### **SSD-9549 – PROPOSED JINDERA SOLAR FARM, LOT & DP, URANA ROAD, JINDERA**

Roads and Maritime Services has reviewed the Environmental Impact Statement (EIS) dated September 2019 prepared by NGH Environmental and the Traffic Impact Assessment (TIA) prepared by Stantec Australia Pty Ltd for the Jindera Solar Farm project. From the information provided it is understood that the proposal is for the establishment and operation of a 150 MW solar photovoltaic (PV) plant and associated infrastructure on the subject site. From the documentation provided, the development will comprise of a series of photovoltaic (PV) modules (approximately 400,000) erected on the site. The PV Modules will be mounted single axis trackers with a maximum height not exceeding 3m above the natural ground level mounted on driven steel posts.

Jindera Solar Farm  
Urana Road / Access Road  
Proposed Basic Right Turn Treatment (BAR)

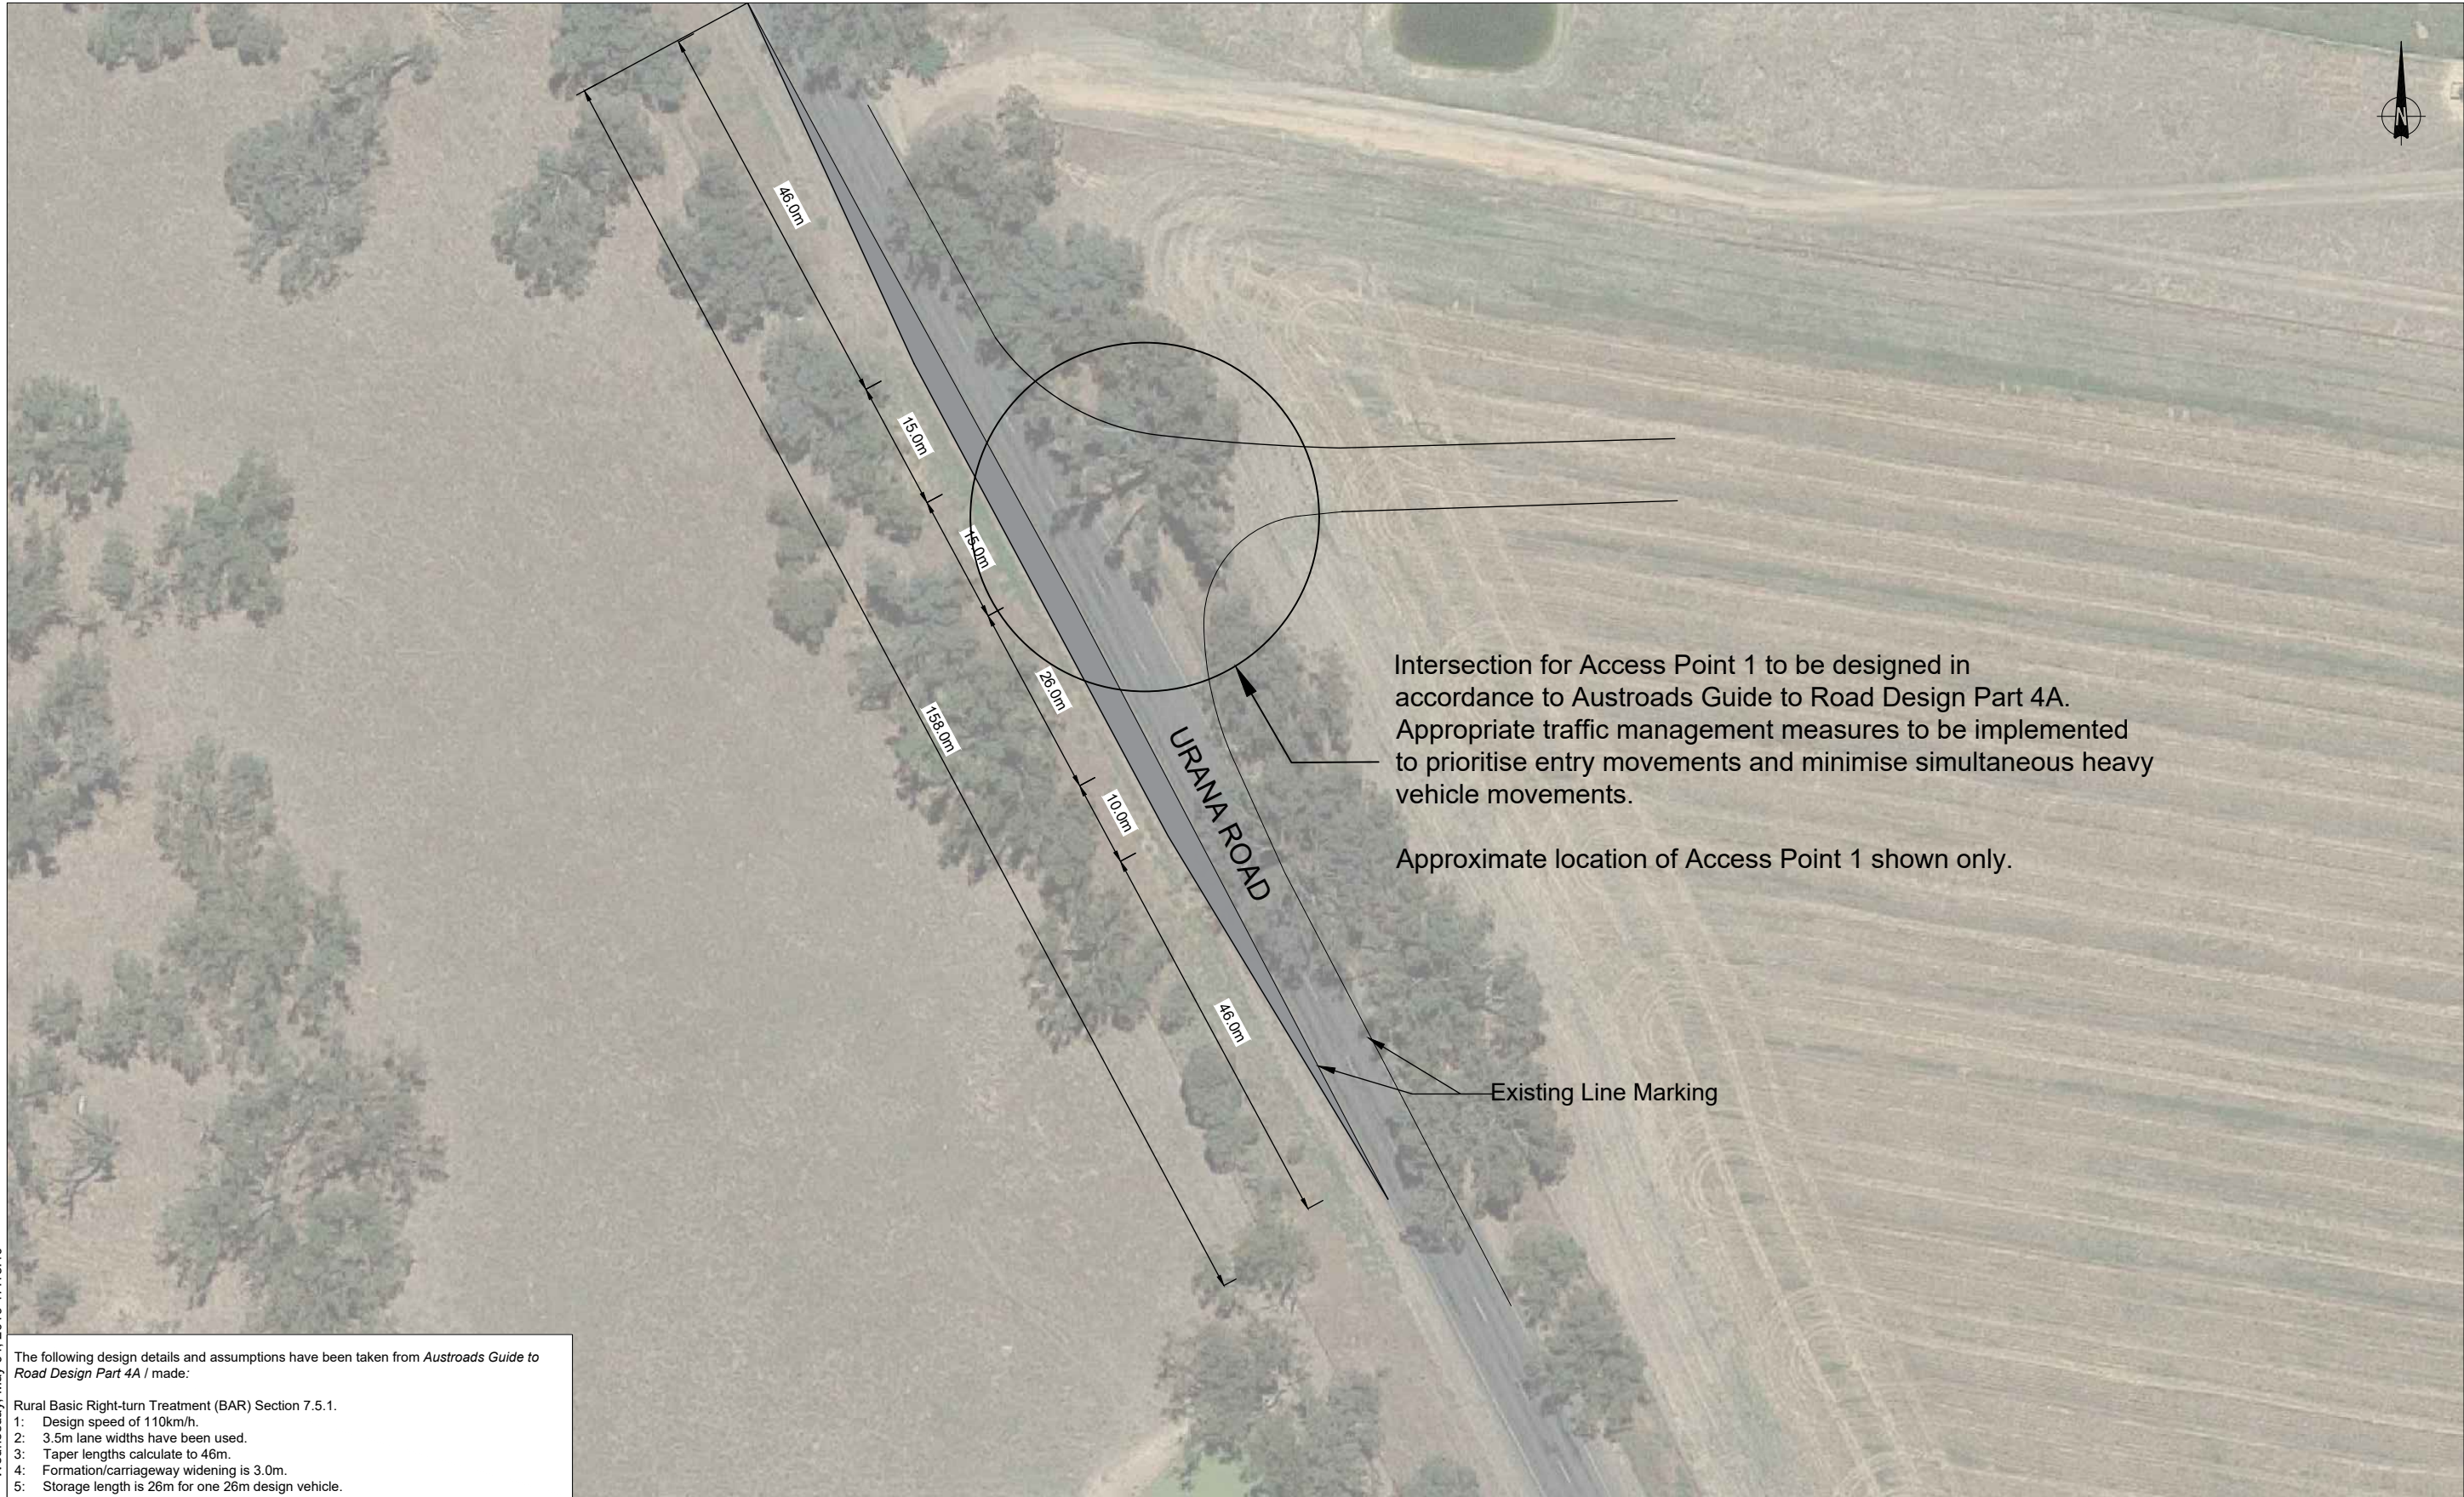
The TIA recommends that a Basic Right Turn (BAR) treatment be constructed at intersection of the proposed driveway from Urana Road to the site. Traffic volumes on the Urana Road in the vicinity of the site are high (approx. 4500 vehicles per day) and the posted speed limit is 100km/h. The bulk of traffic generated by the development is expected to be travelling to the site from the south, hence demand for left turn into the site is expected to be low but right turn volumes are likely to be high during peak times. Considering these factors Austroads guidelines indicate that a Channelised Right Turn-Short (CHR(s)) and Basic Left Turn (BAL) treatment would be an appropriate configuration for the intersection of the driveway with Urana Road. Sight distance requirements under the guidelines will also need to be met.

- i) a Channelised Right Turn -Short (CHR(s))/Basic Left Turn (BAL) for the intersection of the driveway to the development site with the Urana Road (MR125), and
